Re: ACP-324165-26 — Maughanaclea Renewable Energy Development, Co. Cork

Response to the Applicant's Response to Observations

Maughanaclea Renewable Energy Development

ACP CASE REF. ACP-324165-26

Cumulative Context

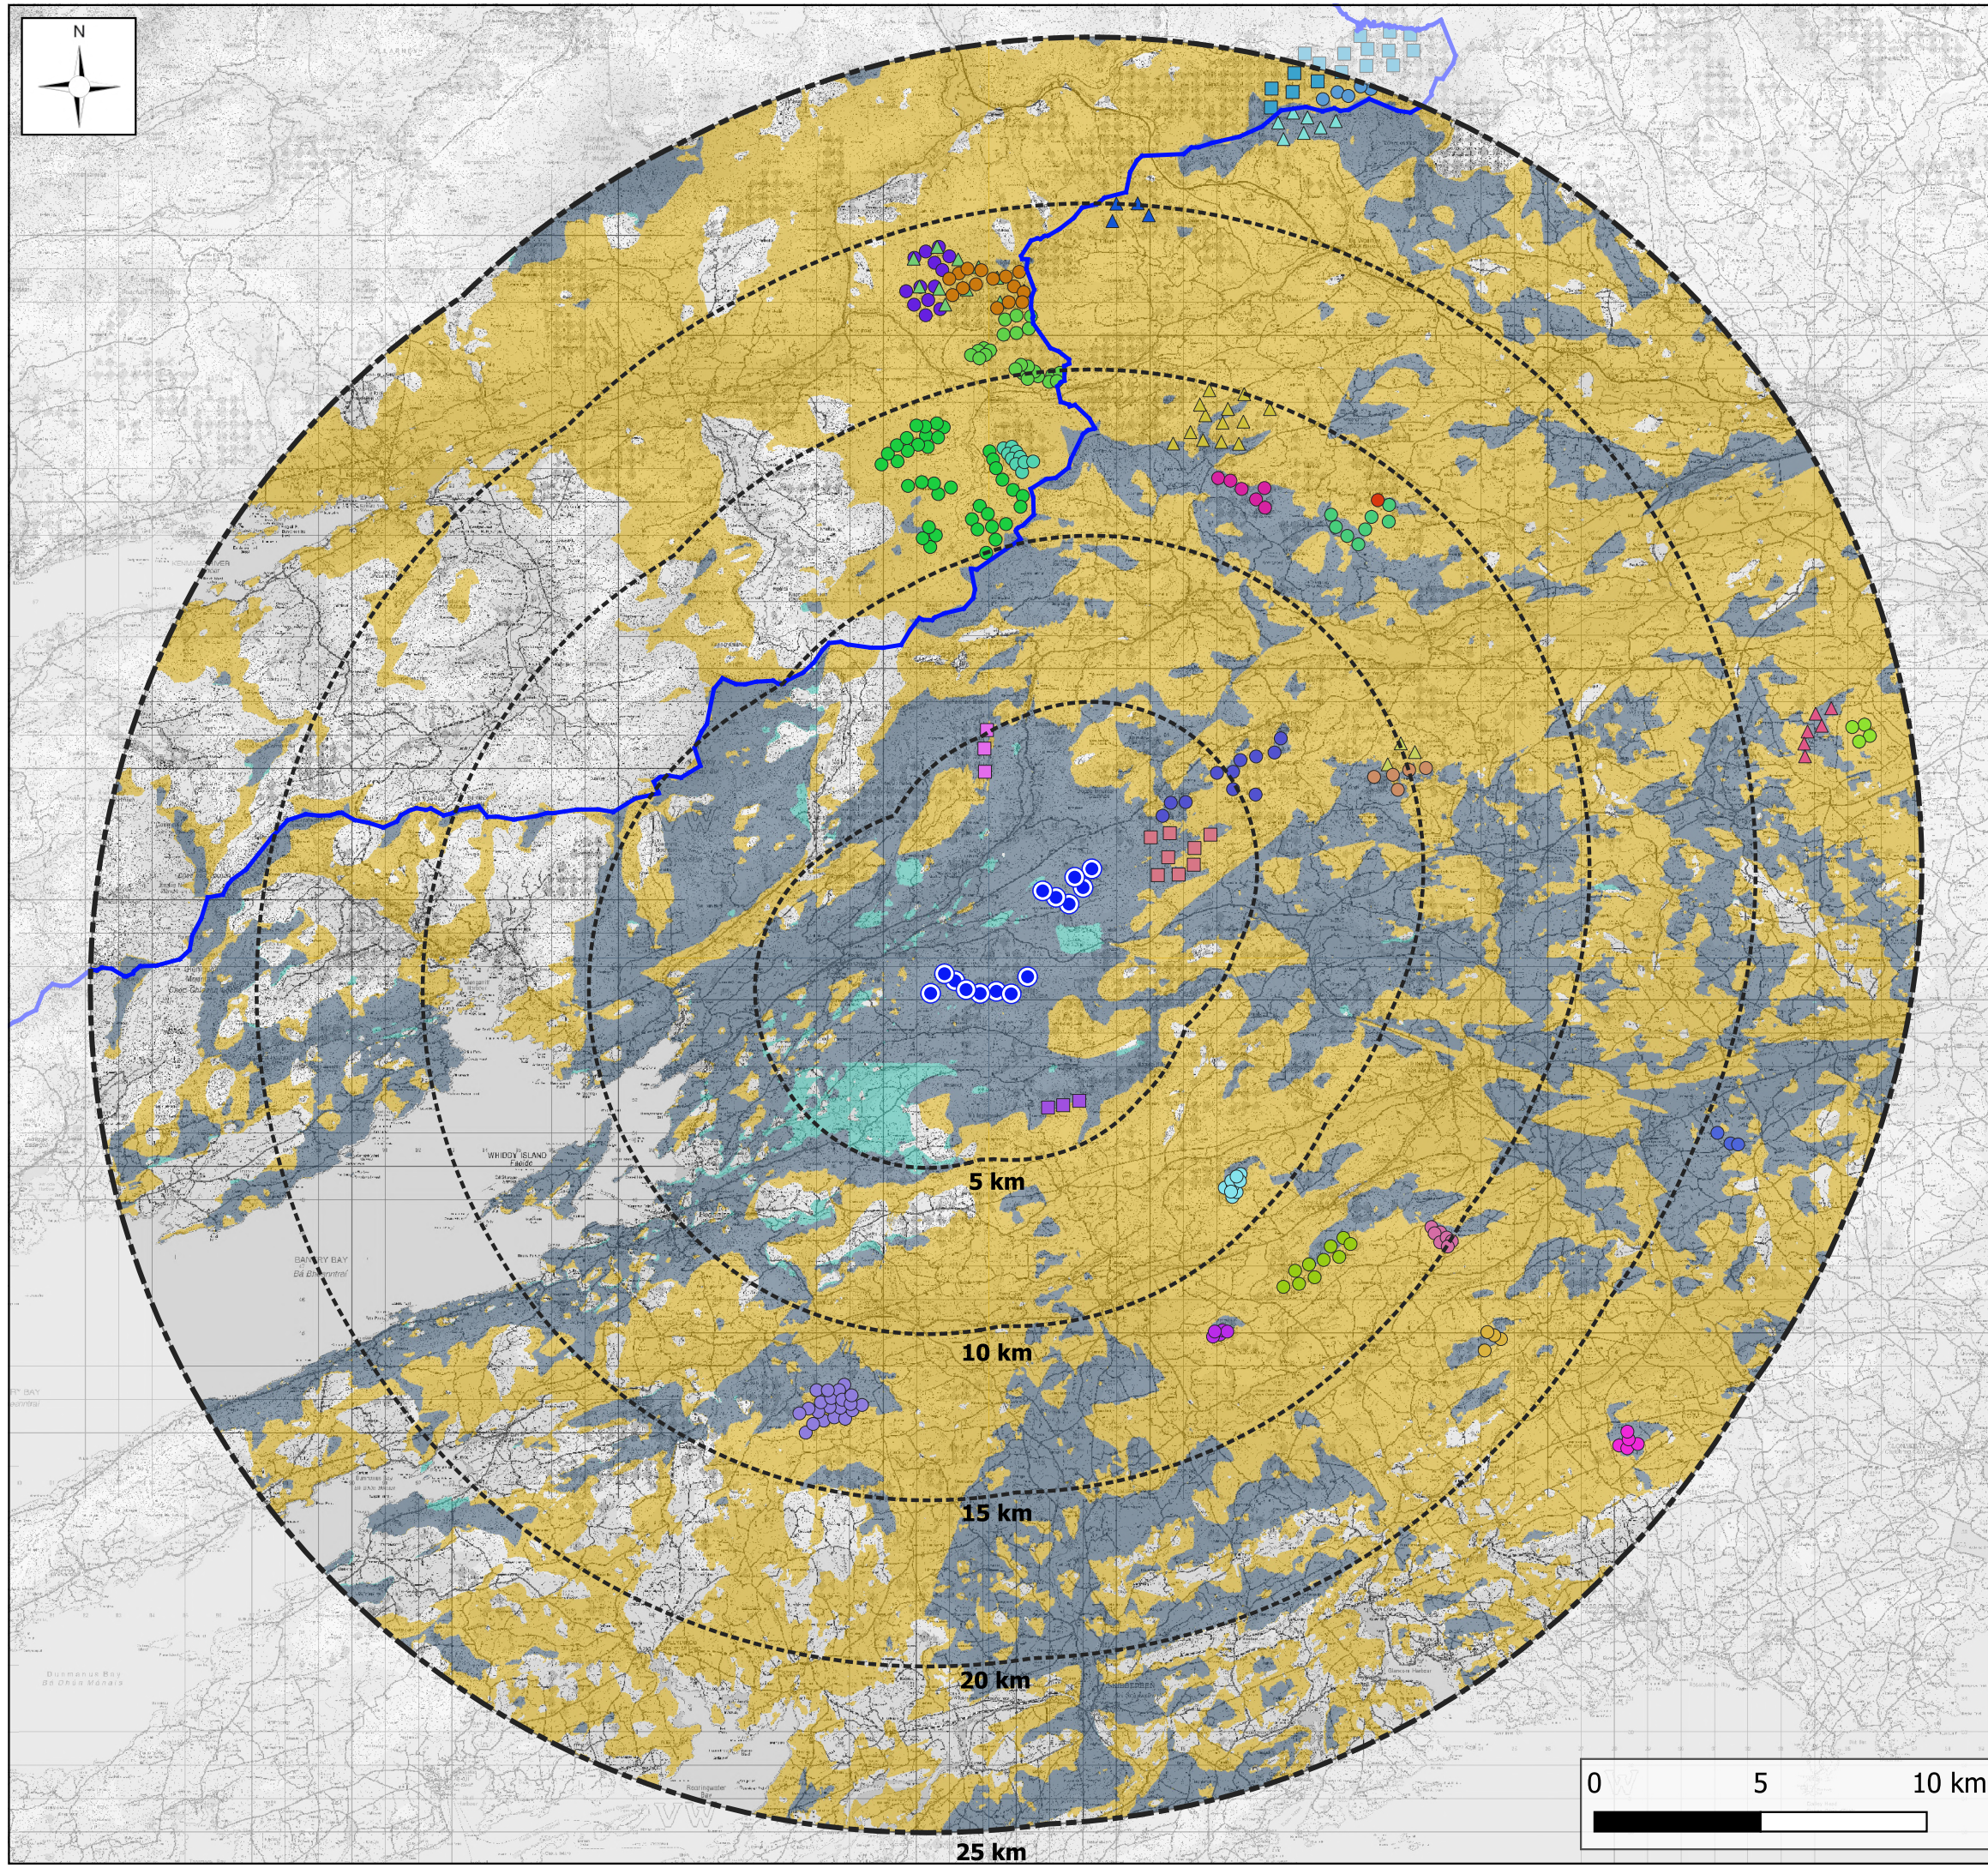
This is irreconcilable with the cumulative treatment in the Maughanaclea EIAR's landscape and visual (LVIA), noise, and project-description chapters, in which Dreenacreenig West is conspicuously absent. Wild Hideaways' original observation of May 2026 documented that omission: Dreenacreenig West was excluded from the cumulative baseline in those chapters despite being one of the closest neighbouring developments to the proposed site — and it has since been granted conditional permission by Cork County Council. The applicant cannot simultaneously include Dreenacreenig West in the ecological cumulative assessment and exclude it from the landscape, visual, noise and lighting cumulative assessments. The selective use of the baseline demonstrates that the project team is fully aware of the development's existence and proximity, yet has excluded it precisely from those assessments in which its inclusion would be most damaging to the application.

We respectfully submit that An Coimisiún Pleanála cannot rely on a cumulative assessment that applies different baselines to different subject matters without methodological justification. The Commission should require the applicant to provide a consistent cumulative baseline across all EIAR chapters — including landscape and visual impact, noise, and aviation lighting.
